DEVELOPMENT HEARING OFFICER

Project Number: PR-2021-005628

Application Number: SD-2023-00034 – FINAL PLAT

Project Name: Tracts A Thru M, City Center

CONCEPTUAL UTILITY PLAN			
MDS CITY CENTER			
DRAWN BY:	AO	DATE:	11/11/2021
CHECKED BY:	MJB	BHI PROJECT NO.	20220088
		SHEET NO.	1 OF 1

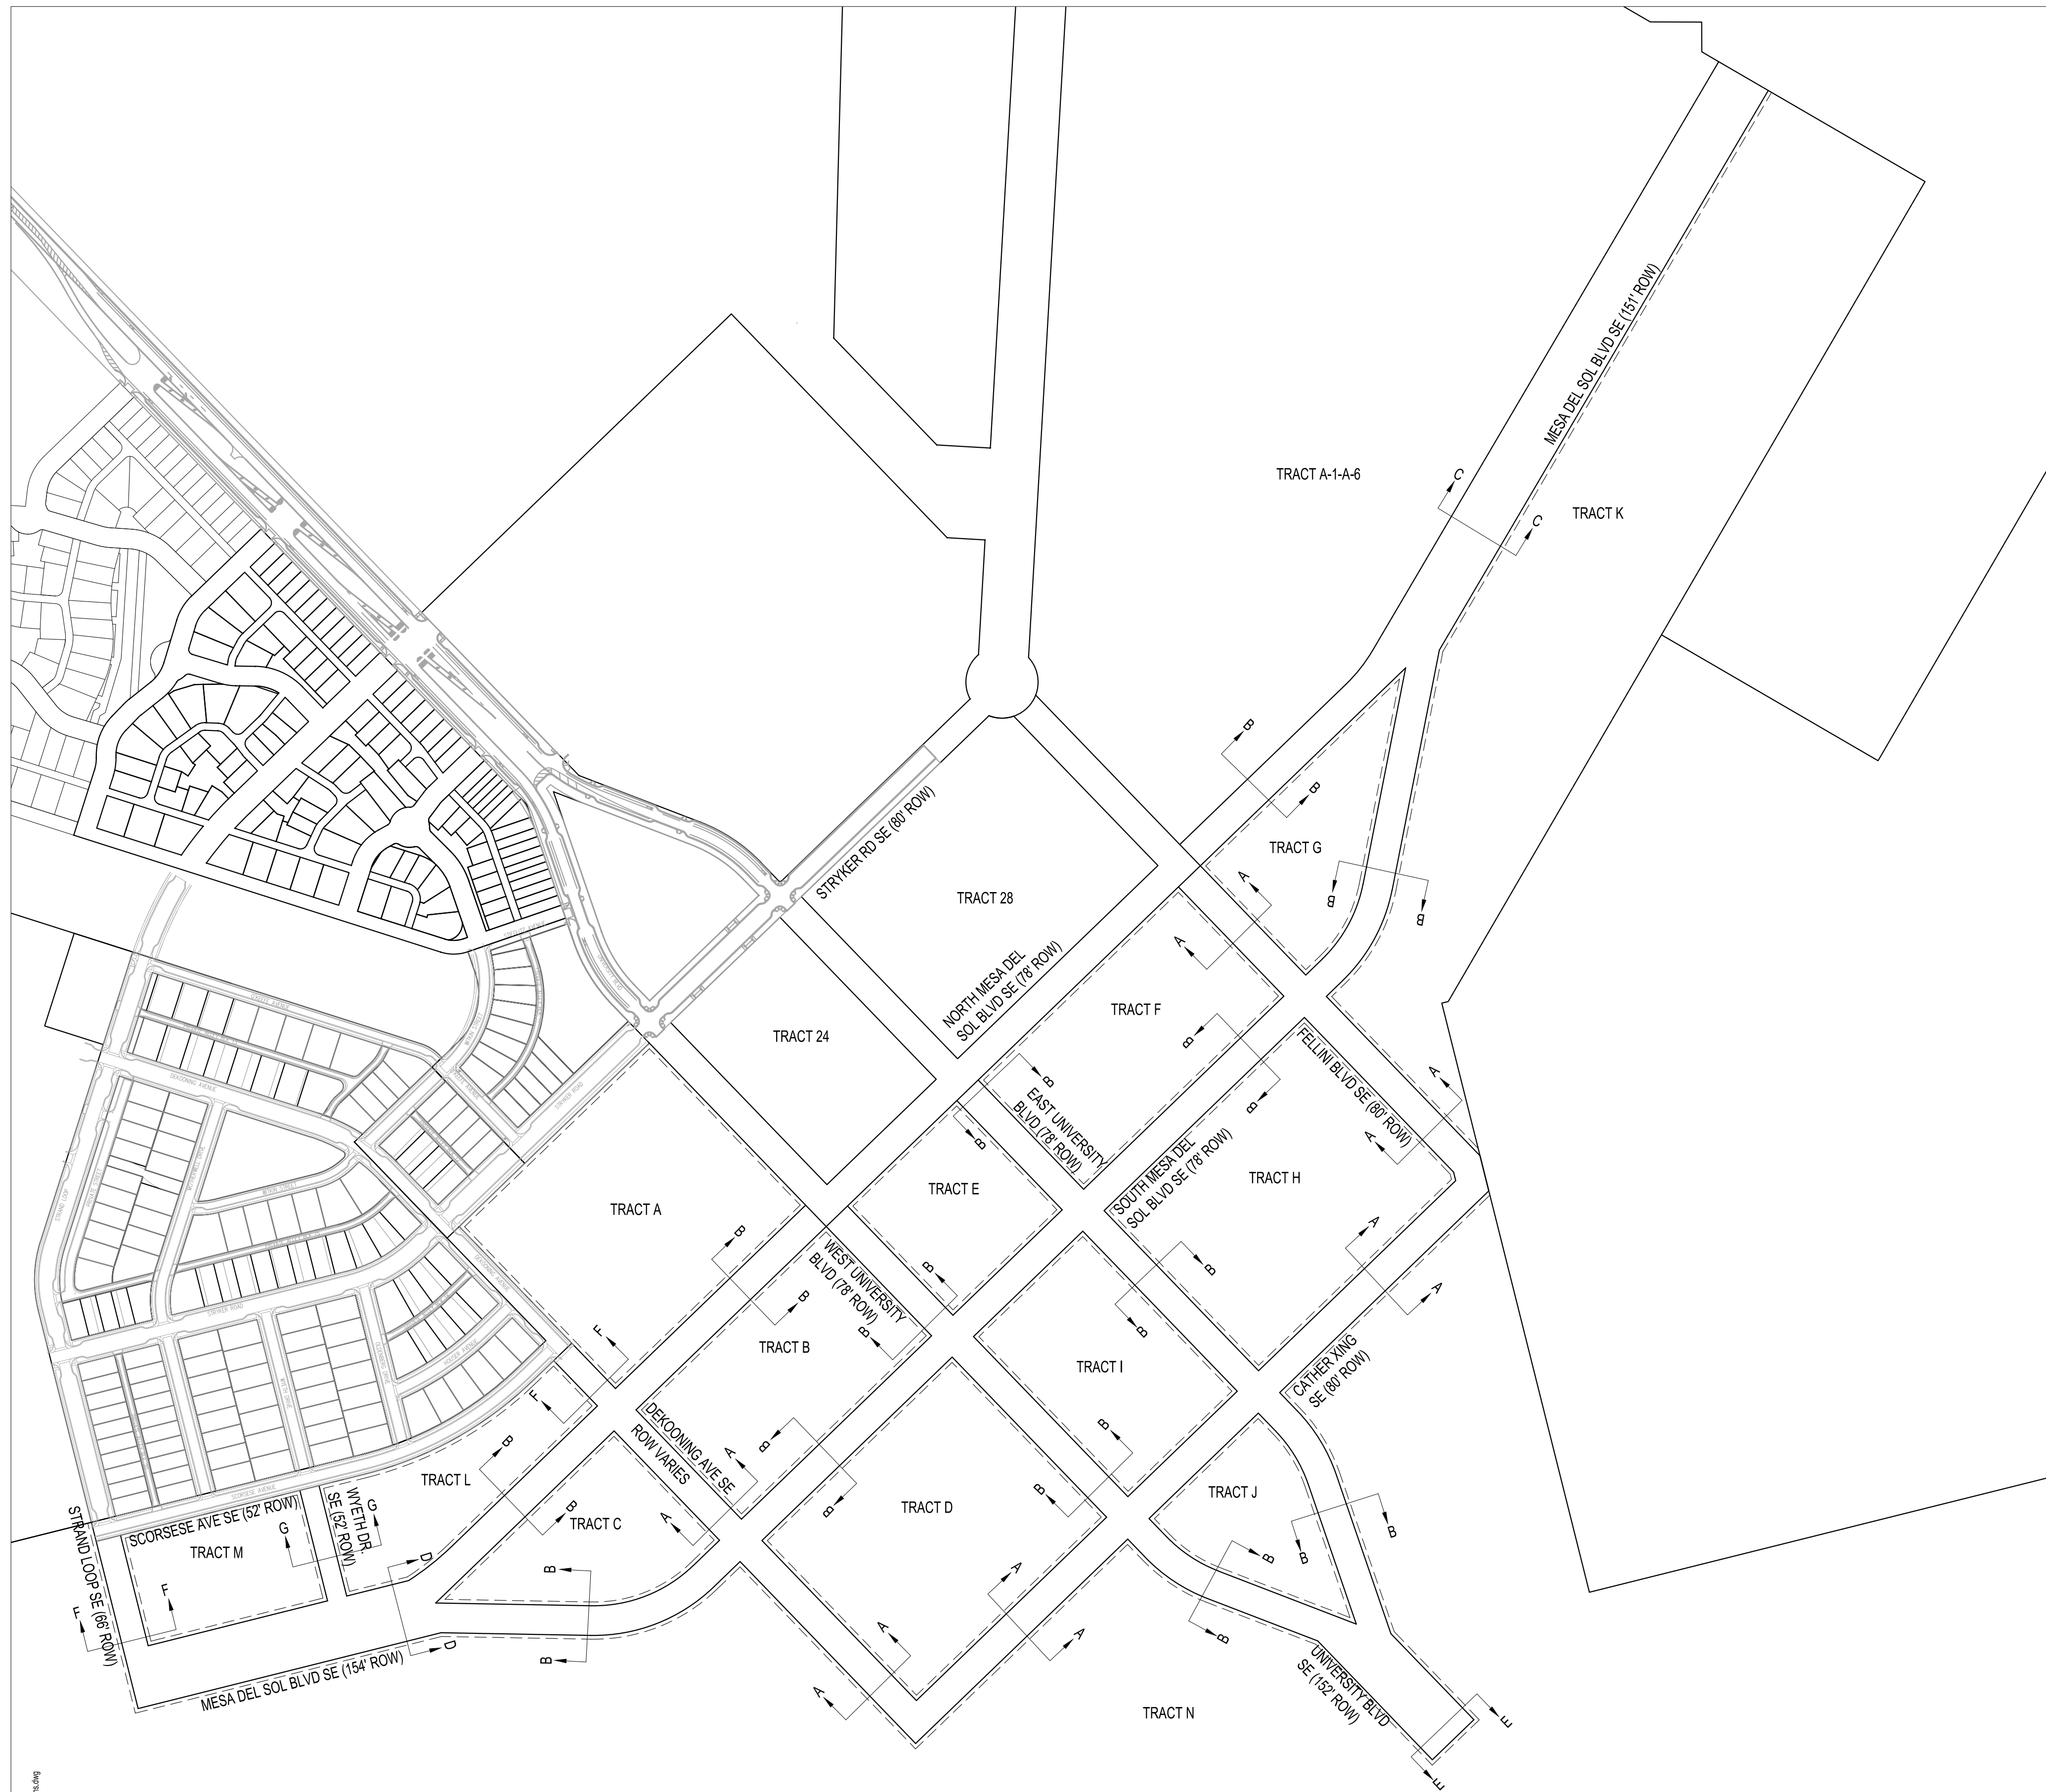
1. No objections to the proposed plat however prior to signature the following items must be resolved.
 - a. Please provide a utility plan to verify the infrastructure list is accurate.
 - i. The provided serviceability letter #211028 has been written to detail what is needed regarding the proposed plat but does not commit service to any of the proposed lots as not enough information was provided to determine infrastructure sizing.
 - ii. All distribution lines are to be guaranteed and listed as 12 inch lines as noted in the Serviceability Letter.
 - b. Easement N calls out ABCWUA Roadway. Please clarify the use of the easement. Should it be public water and public sanitary sewer?

D TYPICAL STREET SECTION - MESA DEL SOL BLVD
(WEST OF WESTERN CORRIDOR)

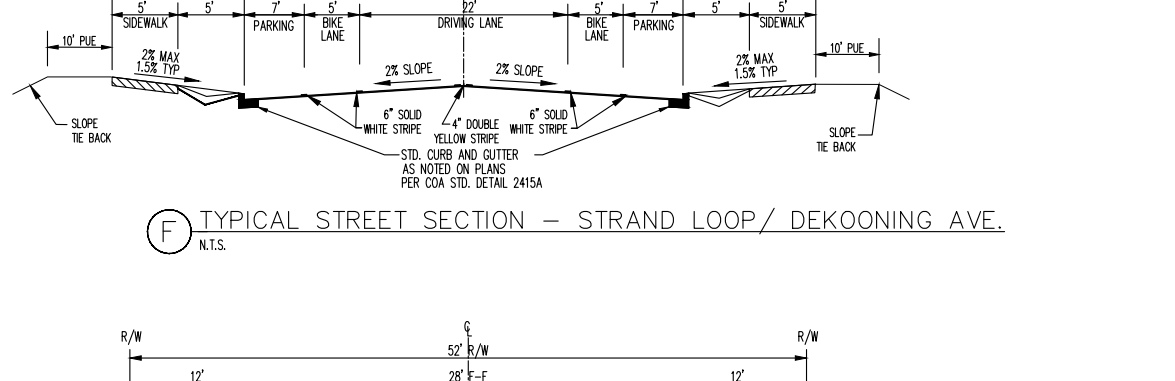
Given recent discussions, one side of Mesa del Sol Blvd west of western couplet could implement a multi-purpose trail in lieu of a 5-ft sidewalk to connect to the multi-purpose trail east of the eastern couplet along Netflix, and to connect westward toward I-25. Can Section D be revised to allow for a multi-purpose trail on one side of the road?

Regarding street section D / Mesa del Sol Blvd west of western couplet, please consider switching dimensions outside of curb to 15-ft for side with multi-use trail and 13-ft for side with sidewalk.

Please confirm the proposed Multi-Use Trail on Mesa del Sol Blvd, West of Western Couplet, is positioned on the north side of the street.

Yes. New Multi-Purpose Trail shown on north side of Mesa del Sol Blvd as discussed.
